CITY OF ALBUQUERQUE

PLANNING DEPARTMENT – Development & Building Services

RE: **Beehive Homes** – SW Corner Four Hills Road and Wenonah NE **L23/D022**
Four Hills Village Shopping Center, Tract 1-B2 **PE Stamp: 7/7/13**
Grading & Drainage Plan for Site Development Plan and Building Permit

Date		Revision		Sheet	
74-223		18		3	
Drawn By		RJ		Date	
Checked By		RHG		AS SHOWN	
Project No		Sect		VERTICAL WALL	
ALBUQUERQUE, N

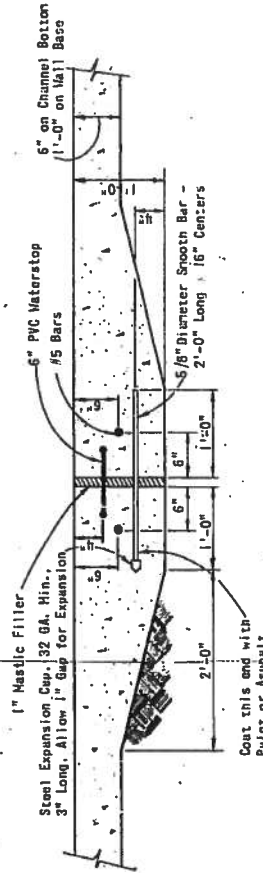
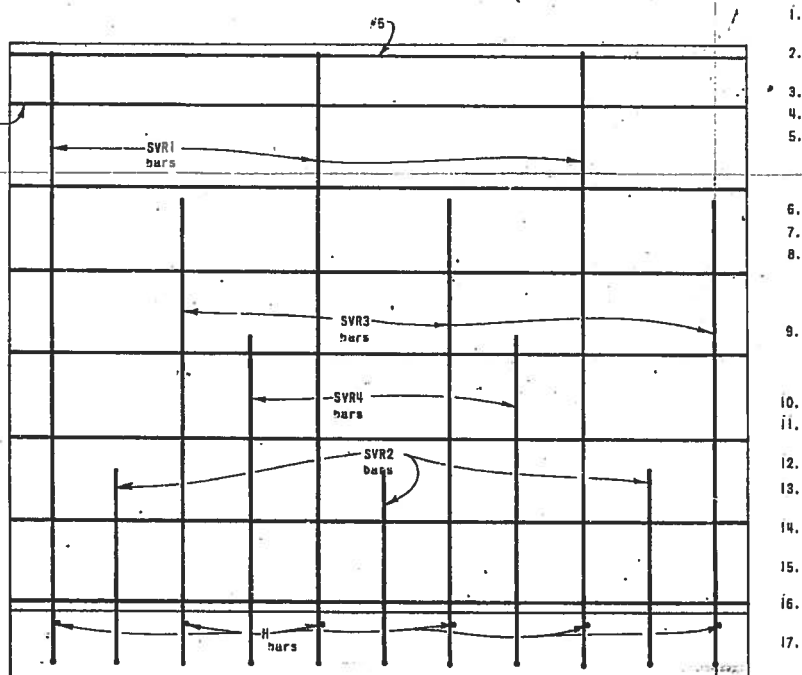
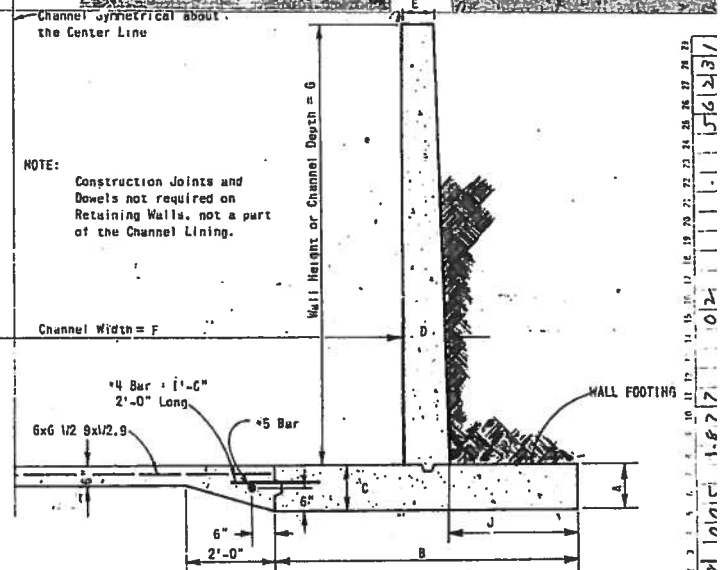
- c. Raise the invert of your connection about 3' above the channel bottom, to minimize the impact of this penetration on the strength of the wall.
 - d. I previously forwarded you a copy of the record drawings for a portion of the Four Hill Channel, which will give you more information on rebar size and placement, and assist in detailing the penetration of the wall.

- e. Details should call for the contractor to locate the existing rebar and adjust the penetration location to minimize the number of vertical and horizontal bars cut. To expedite approval, I suggest that you contact this office to preview your structural connection details, prior to formal submittal.

Drawing file: SCANNED HYDROLOGY FILE BEEHIVE / 05 - 1 Grading and Drainage.pdf

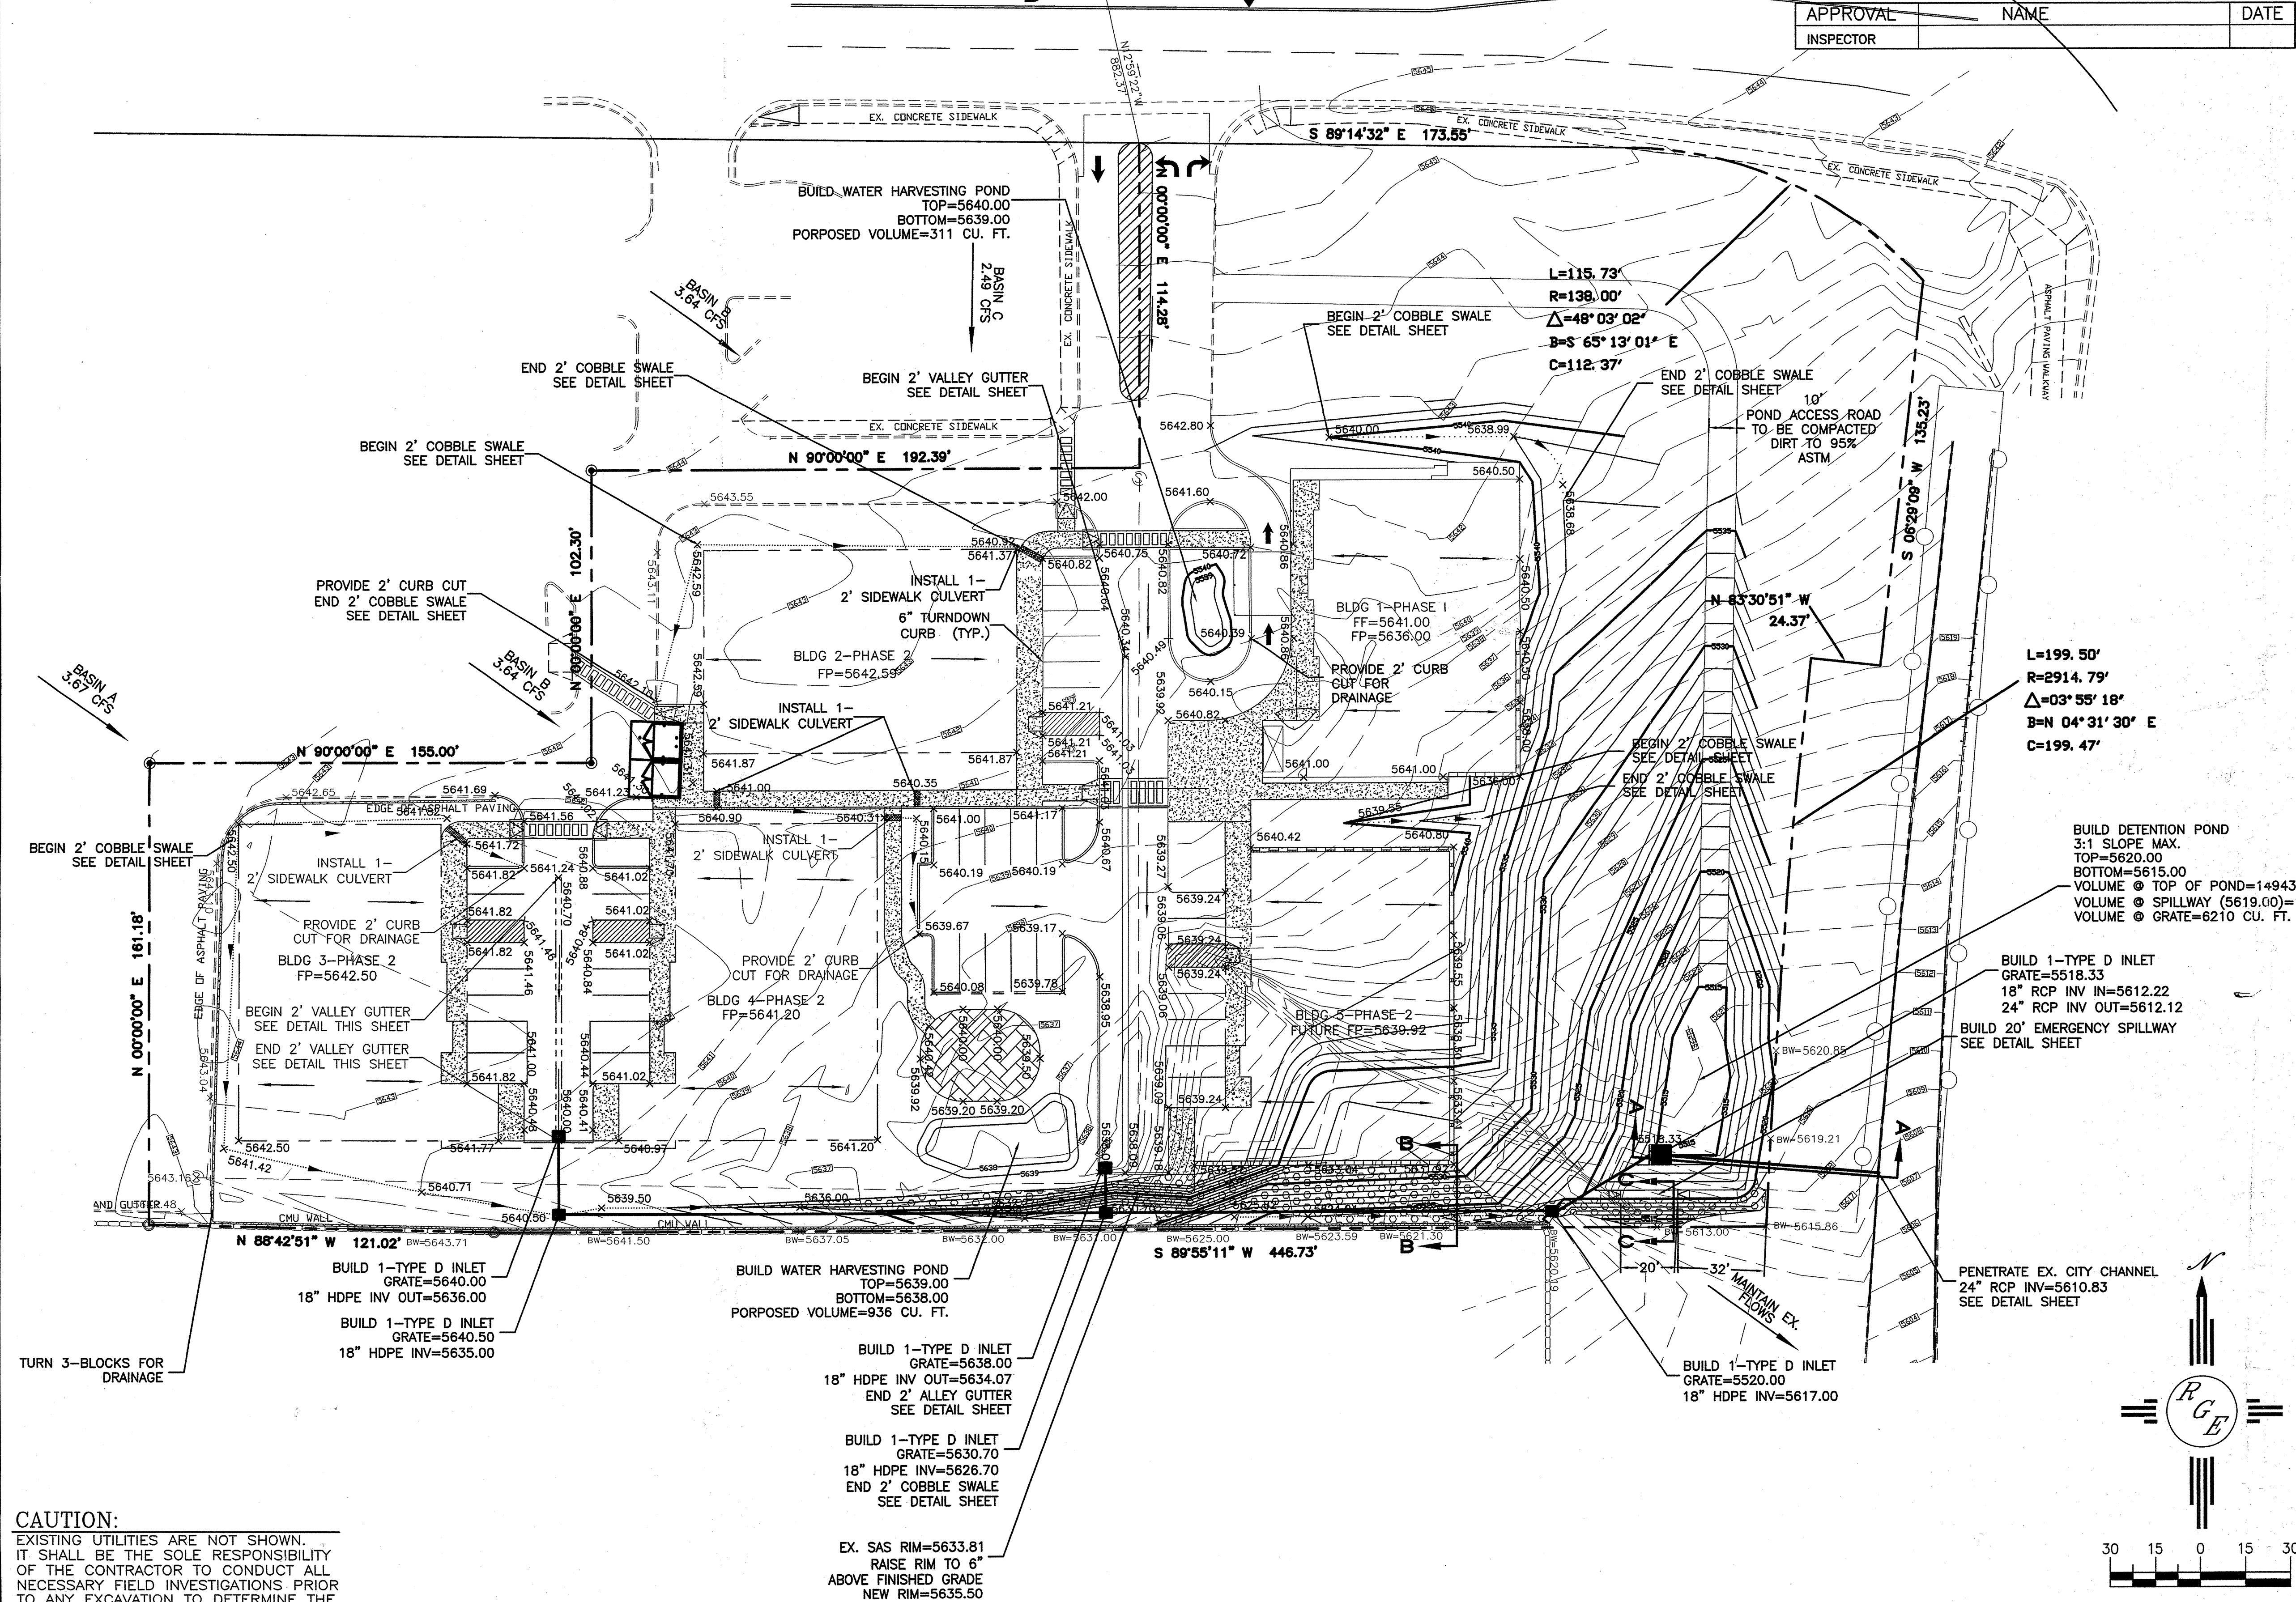
2. The Drainage Report indicates that you are retaining the first 0.44" of runoff from the site. However, the detention pond detailed has an outlet at the bottom of pond, effectively releasing all flows.

- a. Per our discussion, the site storm drain piping will be changed to connect directly to the Four Hills Channel, and by-pass the retention pond.
 - b. The pond at the SE corner of the site will be resized to accommodate expected runoff from the eastern side of the site, and some of the site water harvesting

- will be accommodated in smaller retention ponds on the upper portions of the site, filtering the first flush, and minimizing the outfall pond size?
- c. Raise the grate on the pond inlet, or substitute a stand pipe to set the pond overflow grade and retained volume.

- d. The pond spillway should be located on the south side, coincident with the existing swale.
 - e. Show how retention pond will be accessed for maintenance.

3. Clarify how site “Rough Grading” is intended to be completed, with pad elevations 5-feet below the building FF elevations? This is critical as building completions are expected to be done in phases.

4. Label the building numbers and phases anticipated by the developer.
 5. What is the purpose of the CMU wall shown along the south side of the site? It appears to create a “no-mans-land” between it and the existing garden walls, with no means of access for maintenance. Will the south swale be plated, similar to the 2:1 slope?

6. Drafting issues that need to be corrected:
 - a. Legend symbologies chosen tend to obscure some of the critical details, or are not clearly differentiable. (e.g.- the Retaining Wall and Stem walls are too similar; limits of retaining wall at SE corner; the rock plating obscures contours; etc.)

- b. The proposed contour labels are not legible
 - c. Clarify limits of paving, and add sidewalks/conc.(?) symbol to the Legend.
 - d. What are the limits of the Cobble Swale(s)? Same line type has been used for cobble and non-cobble swales.

- e.
 7. The drainage plan needs to include flow arrows where off-site flows enter the site, and indicate the design Q’s. Also, show how/where on-site flows get into the Water Harvesting Ponds, and indicate estimated volumes retained.

8. Show where roof flows leave the structures and enter the site drainage paths.
 9. Clarify the inlet details at the southern ends of the paved areas, and show how flows will be captured by the inlet, and not allowed to overflow to the landscaped area and steep southern slopes/swale.

10. The flow course between the two central buildings shows flow southerly, crossing under the sidewalk but, the grades slope north. Also, just east of that sidewalk culvert location, flows appear to cross the sidewalk without a pipe or culvert.

11. At the NW corner of the western building pad, the swale appears to cut under the building corner.
12. Clarify grades around parking areas, typical; sidewalk grades vs. pavement grades. Provide flow arrows and Proposed Contours to clarify flow patterns.

13. Records indicate a public sanitary sewer line passing through the site, with a manhole at the south end of your easterly access drive. Show the manhole on this plan, and clarify grades in the area to ensure that site runoff does not drain into the manhole cover openings.
